Appeal NO: ACP ~~ABP~~ - 322154-25Defer Re O/H ☐Having considered the contents of the submission dated/ received 18/12/25
fromGraigie Ballycallan recommend that section 131 of the Planning and Development Act, 2000
be/not be invoked at this stage for the following reason(s): No new planning issuesE.O.: Daniel O'ConnorDate: 8/1/26

Graigue Ballycallan GAA Club's
response to SI31 notice

Graigue Ballycallan GAA Club
Tom Ryall Park
Kilmanagh
Co.Kilkenny
R95VK63
18th December 2025

Case Number ACP-322154-25

Figure 31. Kilmanagh town Tullaroan Stream longitudinal profile and two cross sections showing water levels in the river channel for Existing and Design River System for Q_{100cc} .

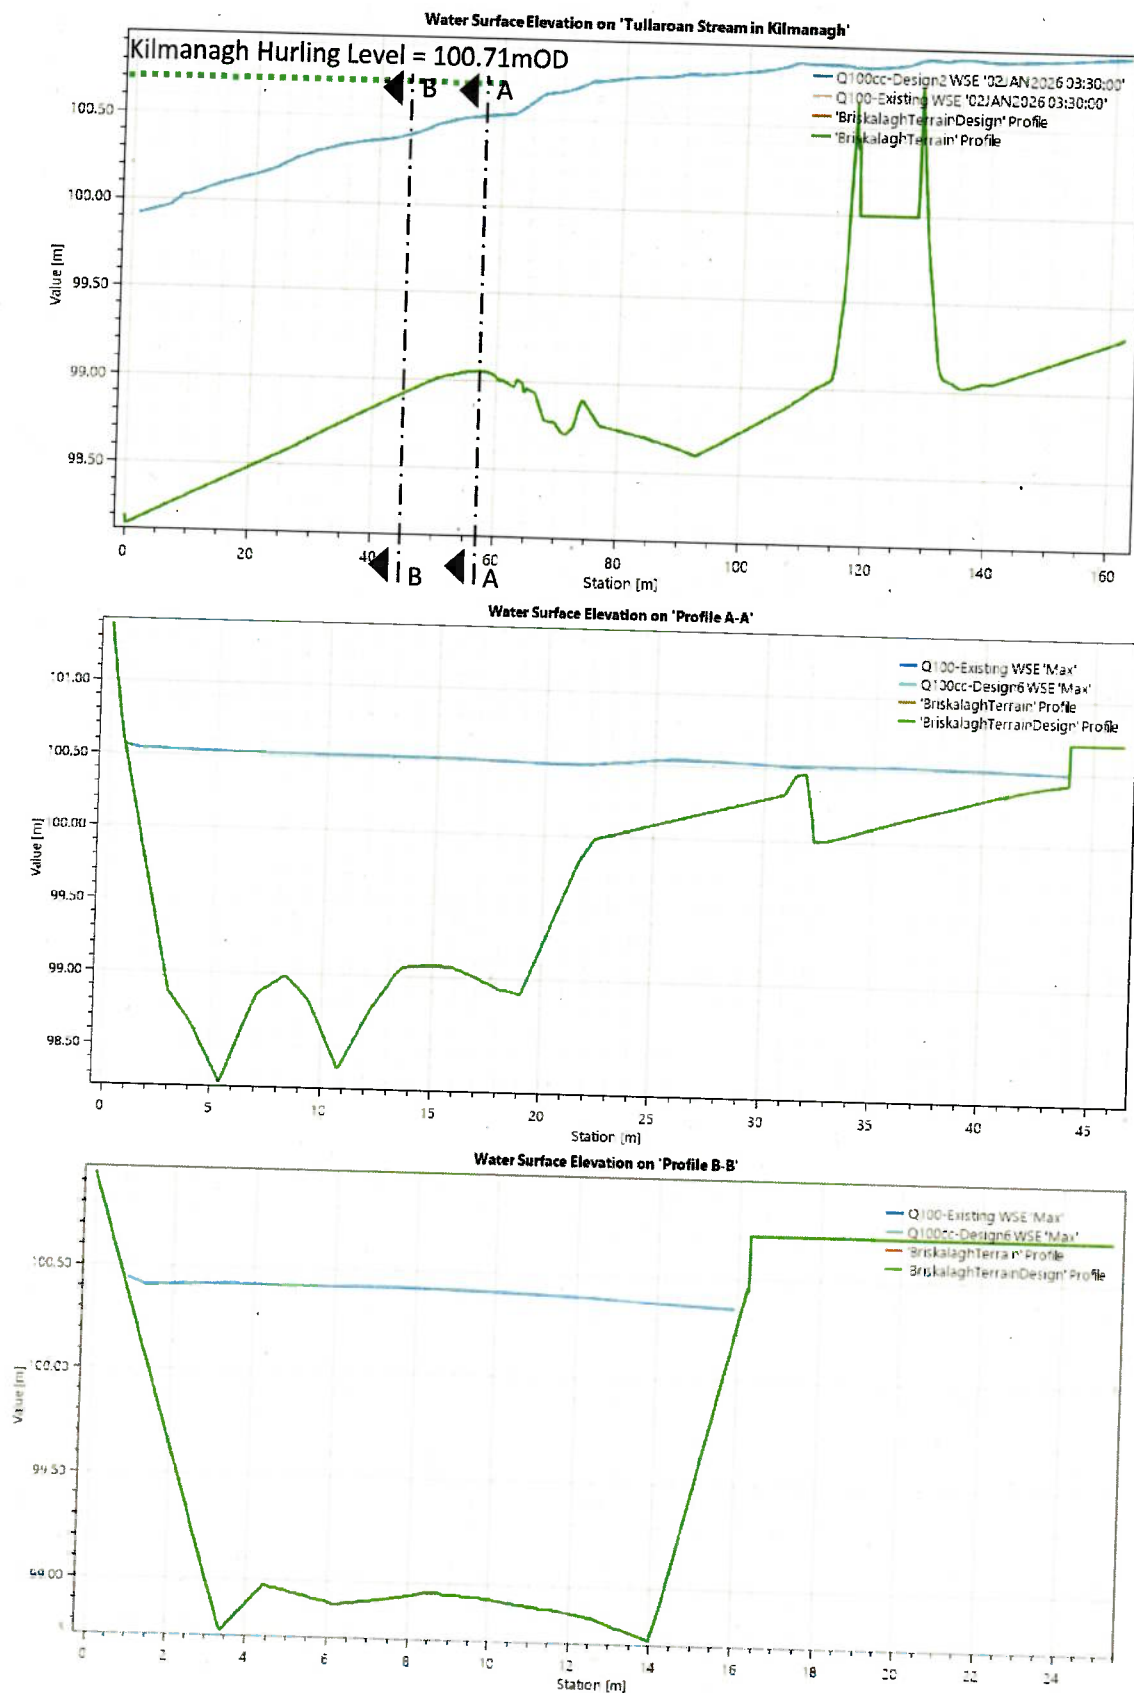
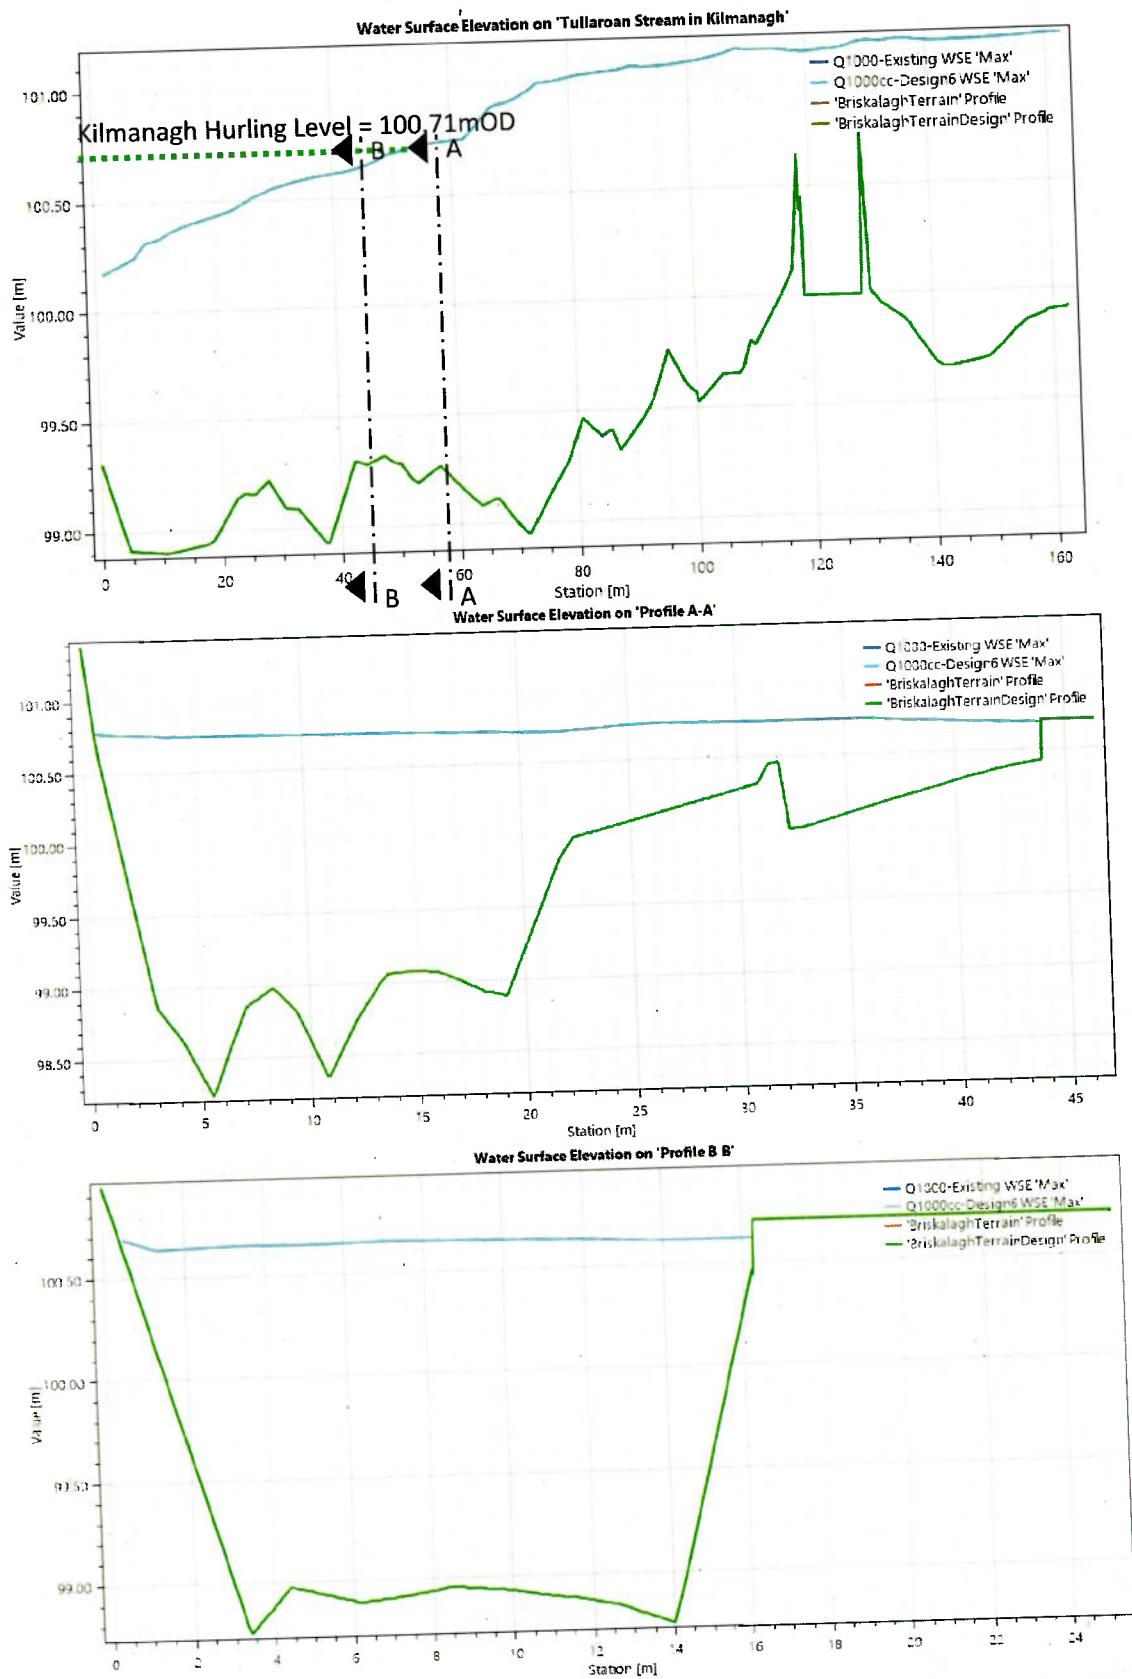
- In the Flood assessment (Fluvio R&D Limited) September 2025 the report refers to the “hurling pitch” in Kilmanagh. We wish to clarify that there are 2 no. pitches located in Kilmanagh with our pitches bounded by Kilmanagh bridge to the North and by the Kilmanagh River to the East.
- Page 50 of the Fluvio R&D Limited report states that special attention was given to flood levels in Kilmanagh town. In particular, and as highlighted in Figures 33 & 34 of the report, it is explicitly stated that during the occurrence of a Q100cc (1 in 100 year + climate change) or a Q1000cc (1 in 1000 year + climate change) the output of the hydraulic modelling exercise demonstrates that **the hurling pitch immediately downstream of Kilmanagh bridge does not flood**. This is a significant and concerning erroneous statement and miscalculation.

- The hurling pitch, e.g. downstream right floodplain **does not flood** for Q100.. and Q1000..'

- To say that the hurling pitch(es) in Kilmanagh are only in danger of 1 in 100 year or 1 in 1000 year floods is simply erroneous as our original submission contained photographic evidence of extreme flooding of the hurling pitches in October 2022 and again in October 2023. As recently as the 11th November 2025 one of the pitches was flooded up to 304mm.

- This flood event had an estimated return period of 1 in 15 years to 1 in 20 years at this location, however the assessment and analysis undertaken by Fluvio R& D Limited presents that the hurling pitch would not be subject to flood inundation up to the 1 in 1000 year + climate change flood event. This demonstrates that this Site Specific Hydraulic Modelling exercise is significantly flawed and does not provide any confidence whatsoever in relation to the potential adverse impact of the proposed wind farm development on the existing hydrological regime of the area.

- The hydraulic model used by Fluvio only extends for a distance of approximately **60m** downstream of Kilmanagh bridge. Our club grounds extend for approximately **500m** downstream from Kilmanagh bridge. In this regard the hydraulic model in no way represents the existing baseline scenario and proposed development scenario hydrological and flood regime at Kilmanagh. This is demonstrated by the point discussed above.
